HINCKLEY NATIONAL RAIL FREIGHT INTERCHANGE

Applicant's Comments on Written Representations [Part 2 of 4 Local Planning Authorities]

Document reference: 18.3

24 October 2023

Written Statement of Oral Case ISH6 [Appendix C – Plan for A47 link road footway/cycleway design]

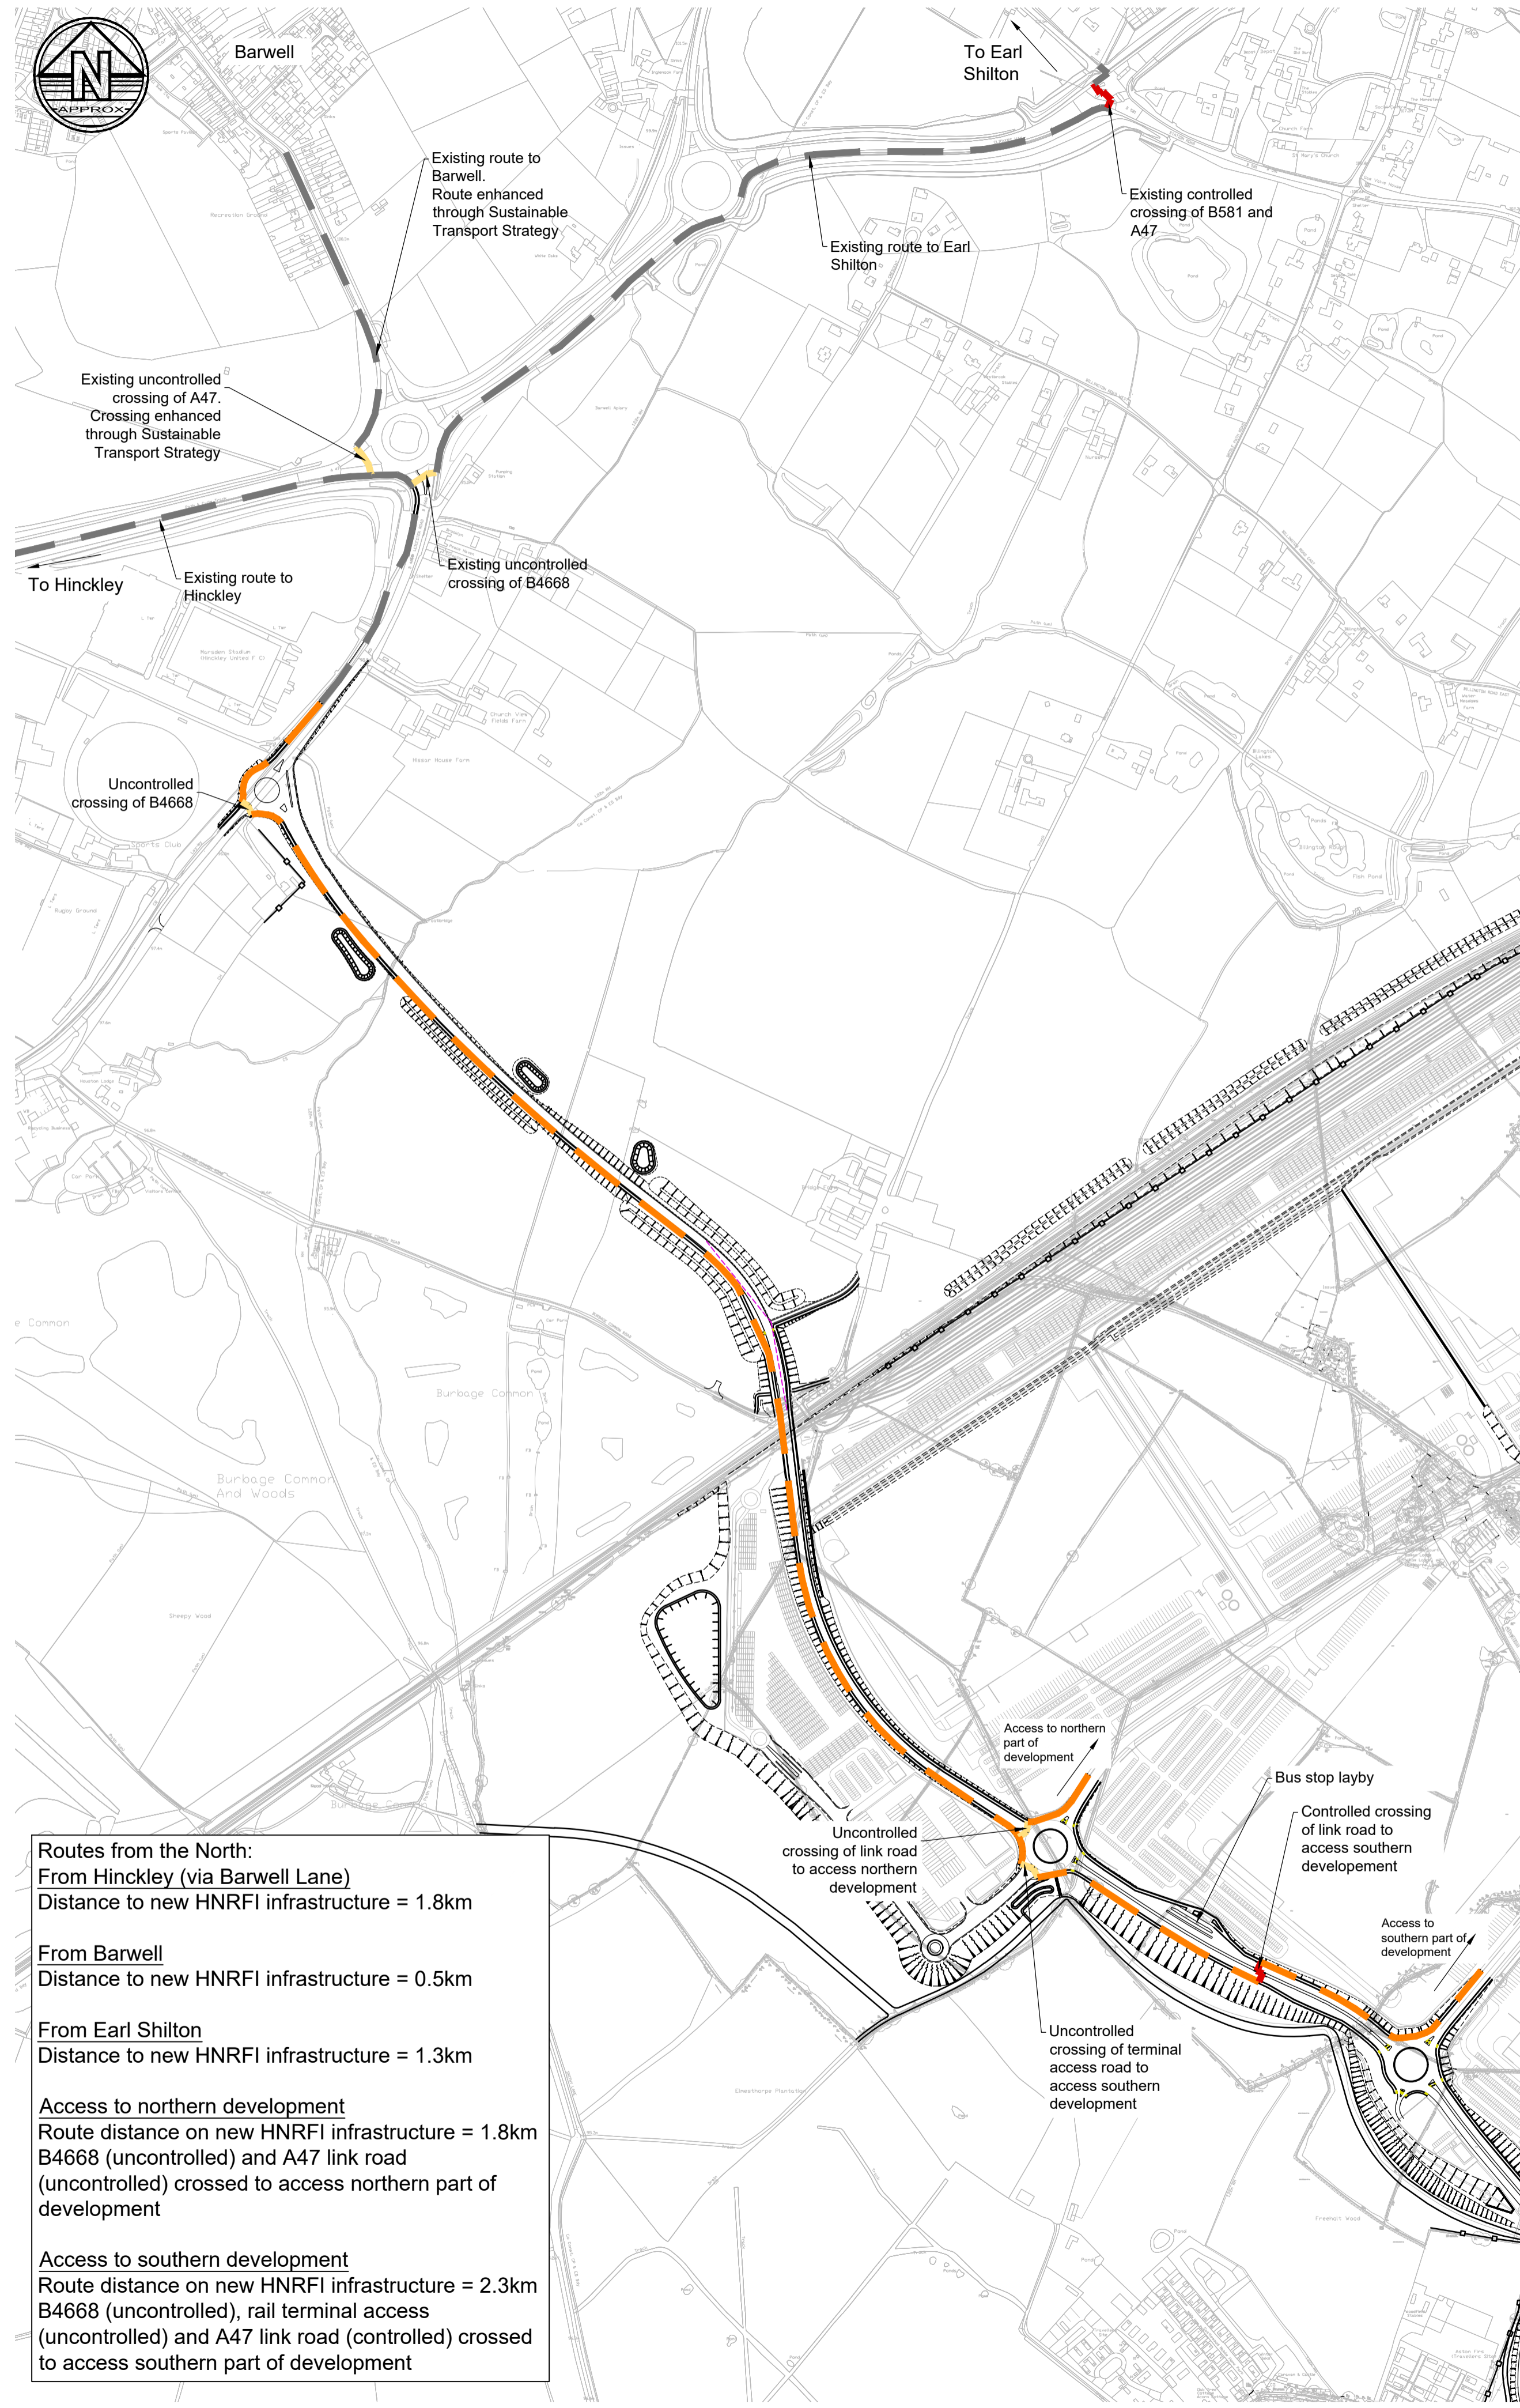
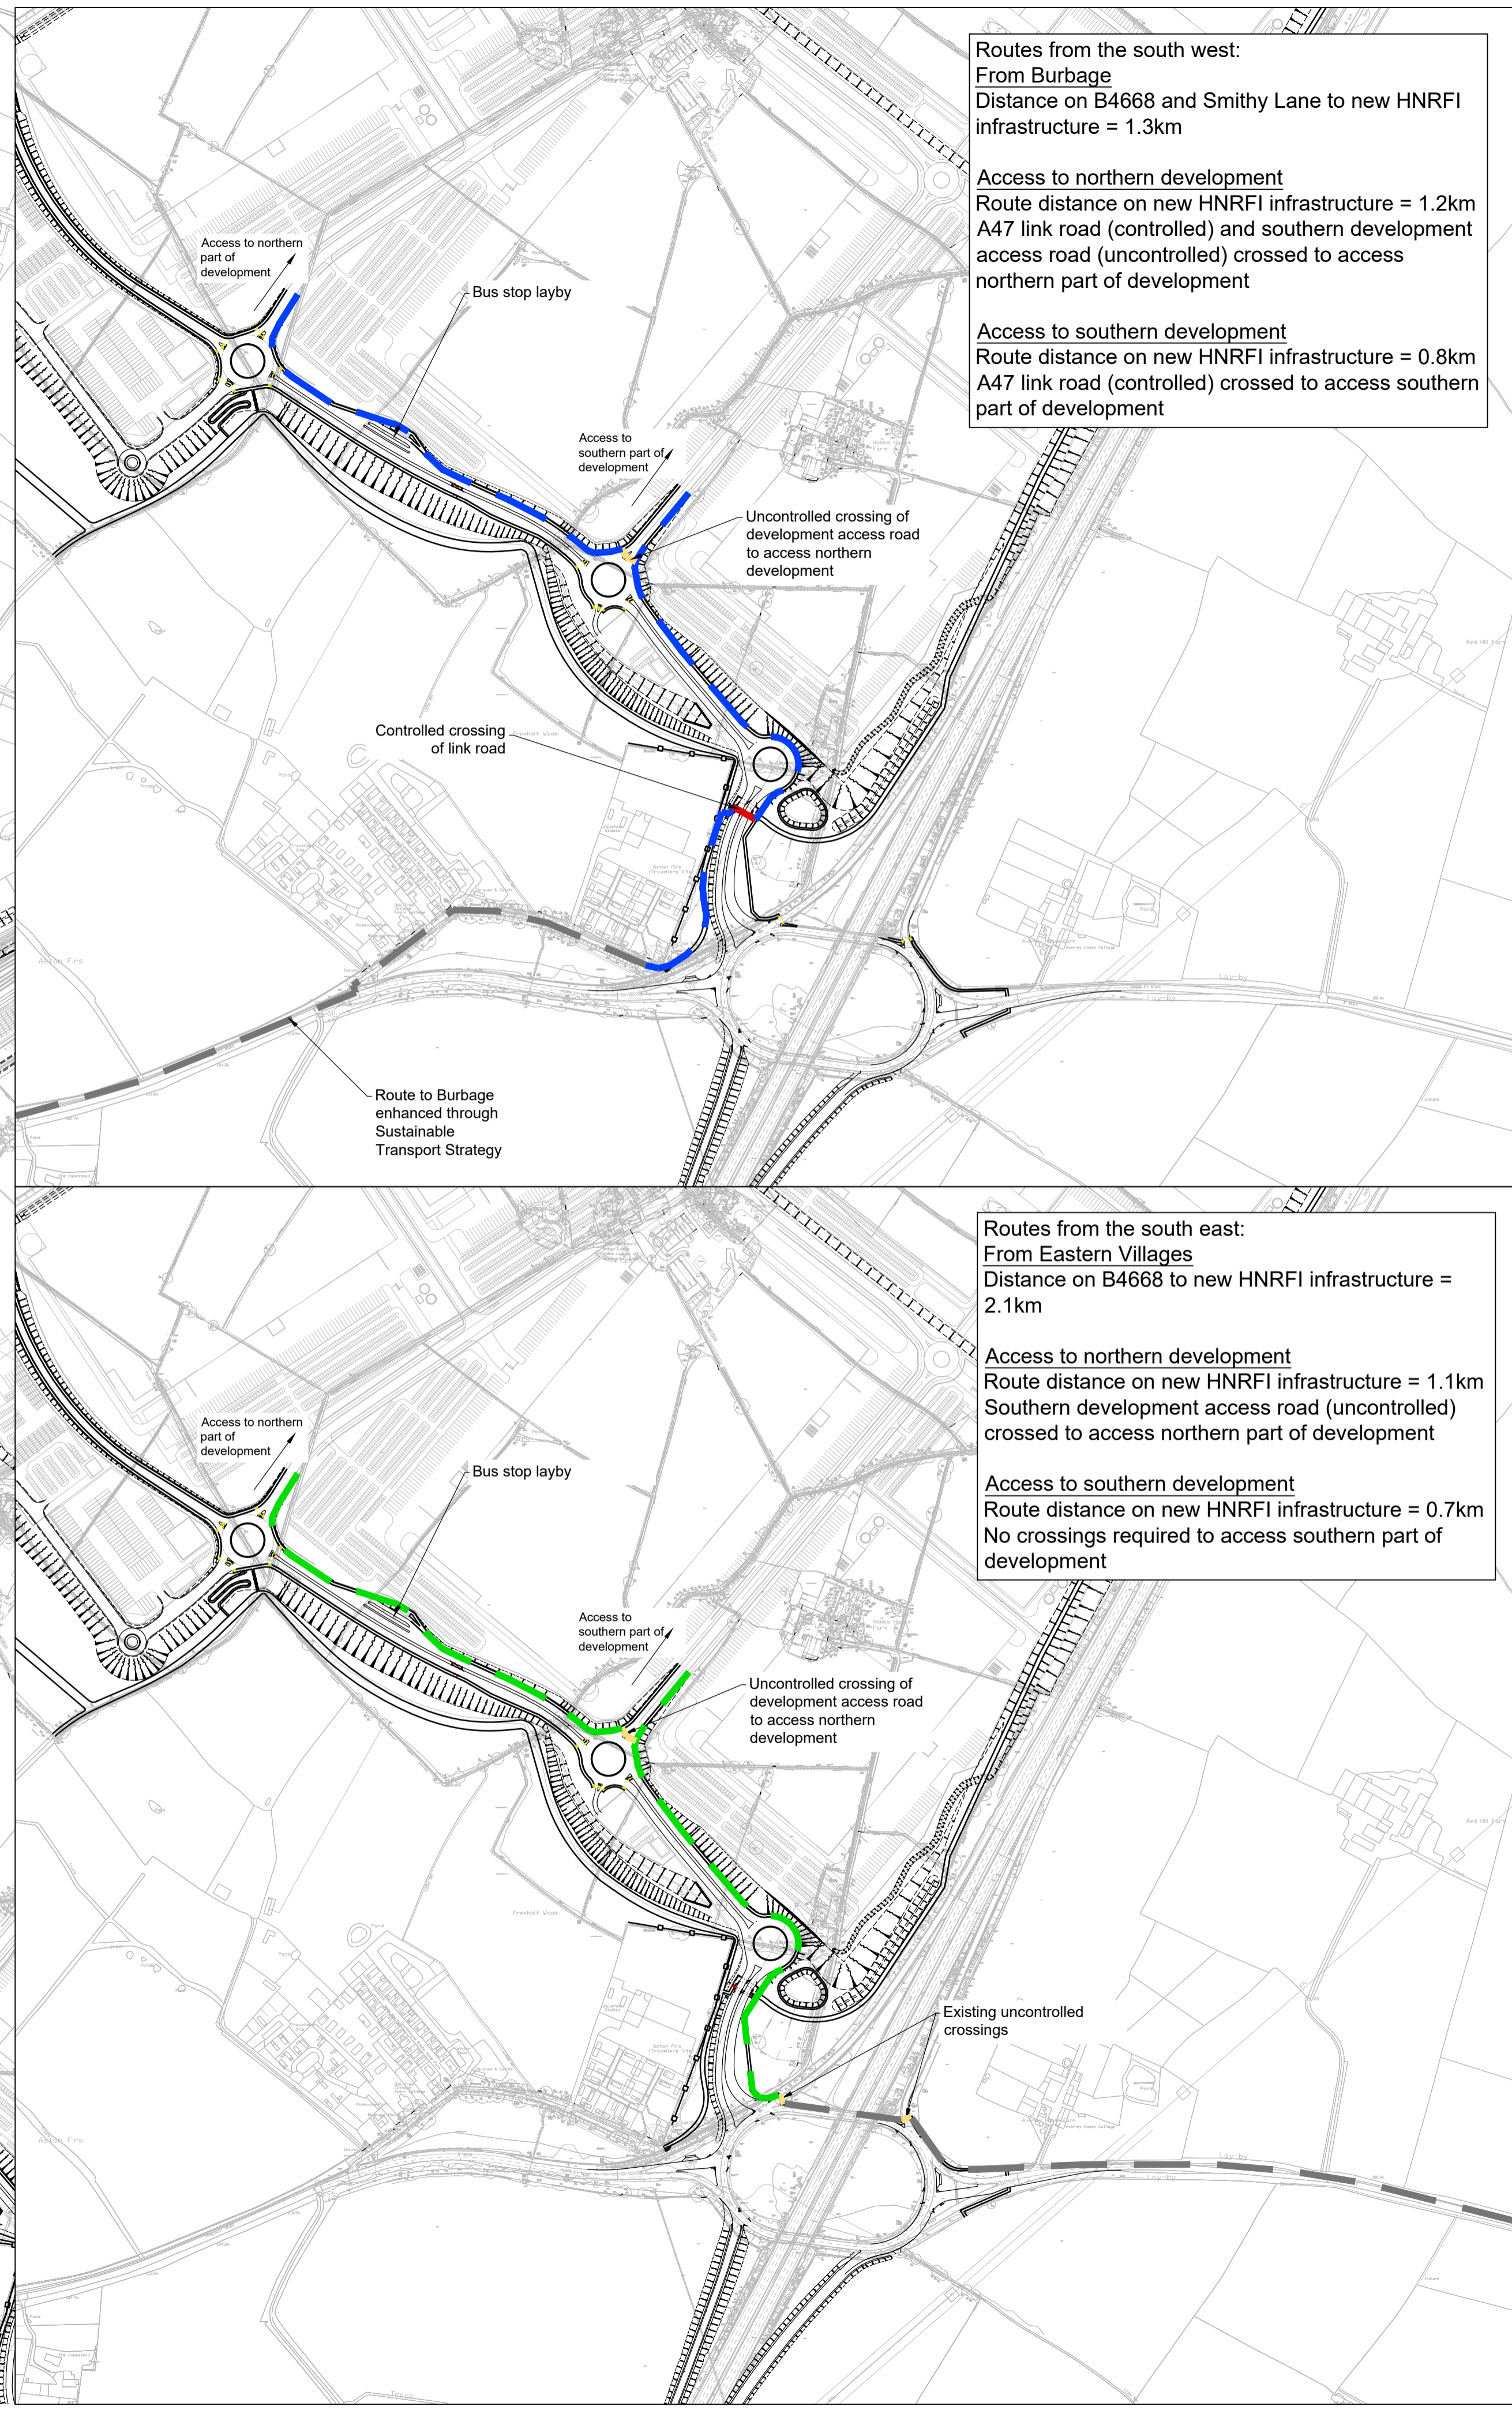
<p>Leicestershire County Council</p>	<p>From the scale of the drawings submitted it appears that the link road includes for a 3m footway/cycleway which does not appear to be continuous and would require pedestrians and cyclists to continually cross the road, not always with designated crossing provision. APP-011 does appear</p>	<p>See response to LCC LIR for further detail (document reference 18.4) (response number 1)</p>

Name/Organisation	Summary of Representation	Applicant Response
	<p>to include for a pegasus crossing and a toucan crossing. However, it remains unclear how these facilities link with footway/cycleway provision. The drawing does not include for connections to existing provision on the B4668 Leicester Road, creating gaps in pedestrian and cycle provision for employees drawn from the villages of Barwell, Earl Shilton and Elmesthorpe.</p>	
<p>Leicestershire County Council</p>	<p>LCC LHA have reviewed the VISSIM model for M69 J2. LCC LHA note that whilst the model includes for the proposed pegasus crossing it does not account for this being called i.e., being used by pedestrians, equestrians and cyclists. This will clearly impact the capacity of the junction and the link road but does not appear to have been accounted for.</p>	<p>See response to LCC LIR for further detail (document reference 18.4) (response number 27)</p>
